WEST SUSSEX COUNTY COUNCIL CONSULTATION

TO:	Arun District Council FAO: Emma Sheppard
FROM:	Stephen Gee WSCC – Highways Authority
DATE:	23 July 2025
LOCATION:	Land to the West of New Courtwick Lane Wick BN17 7RZ
SUBJECT:	LU/72/25/OUT Hybrid Planning Application comprising of the following: 1)-Outline application with all matters reserved (except access) for Phase 2 (West of Site) comprising development of approximately 8,800sqm GIA Light Industrial/Storage and Distribution (Use Class E(g)(iii) / B8), and 2)-Full Application for Phase 1 (East of the Site) for a food store (Use Class E(a)), 2 No Drive-Thru food/beverage units (Sui Generis) with revised vehicular access, associated parking and landscaping. This application may affect the setting of a listed building and is in CIL Zone 2 and is CIL Liable.
DATE OF SITE VISIT:	
RECOMMENDATION:	More Information

WSCC Highways response

Figure 7 - Proposed Site Masterplan

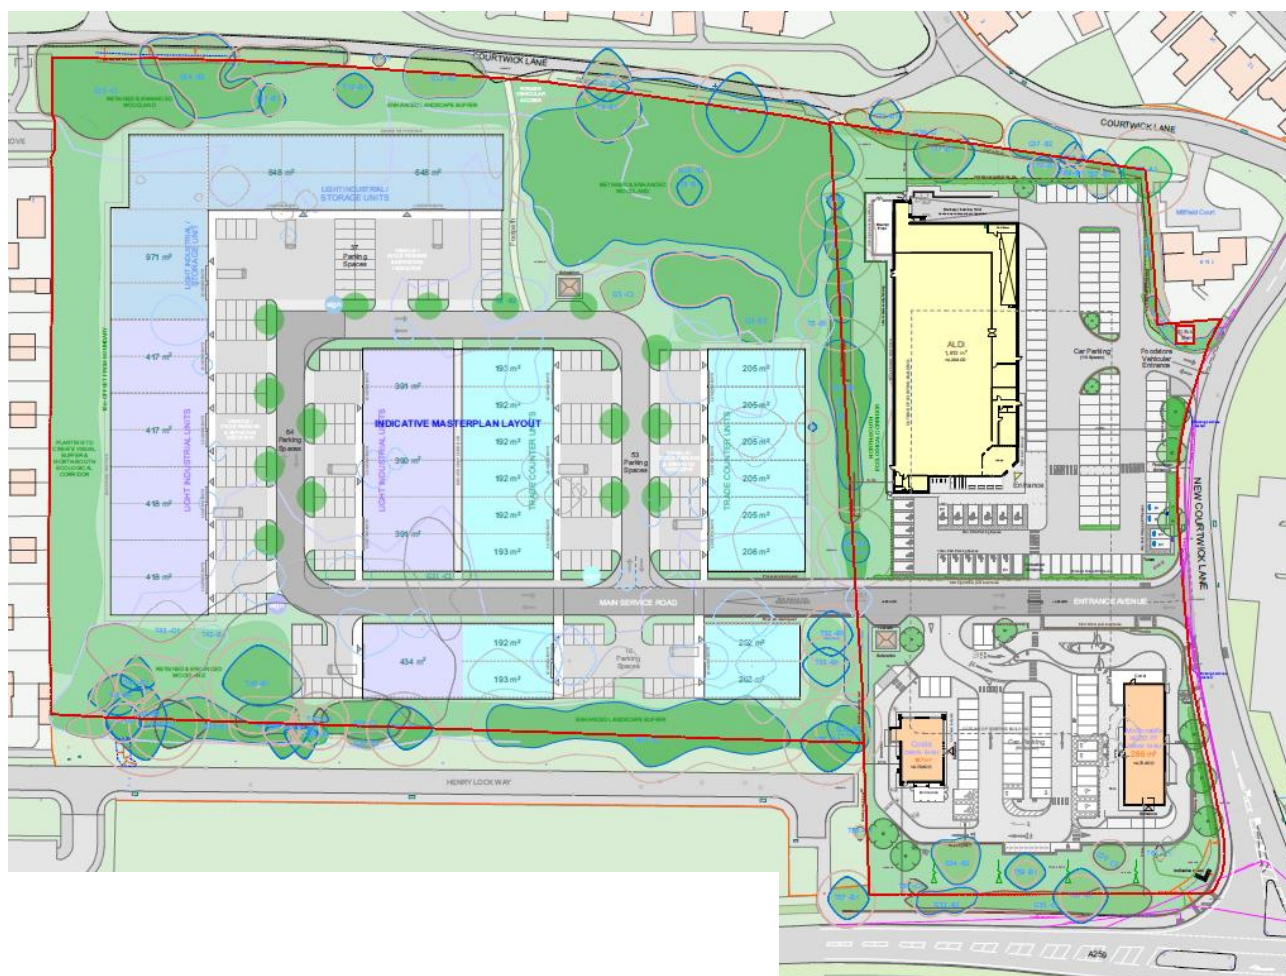
As per my previous response (but erroneously not included in the conclusion) further information is requested upon the connection to the north of phase2 and the applicant's ability to complete the link.

The phase 2 layout shows a footway being provided onto Courtwick Lane to the north at a former vehicular access (stated as existing pedestrian access within the planning statement). The footway would provide some permeability through the site. From the supporting plans provided works would be required outside the redline boundary to provide a connection to the carriageway and it does not appear on the WSCC Highway boundary mapping.

Ability for the applicant to deliver works to connect to Courtwick Lane.
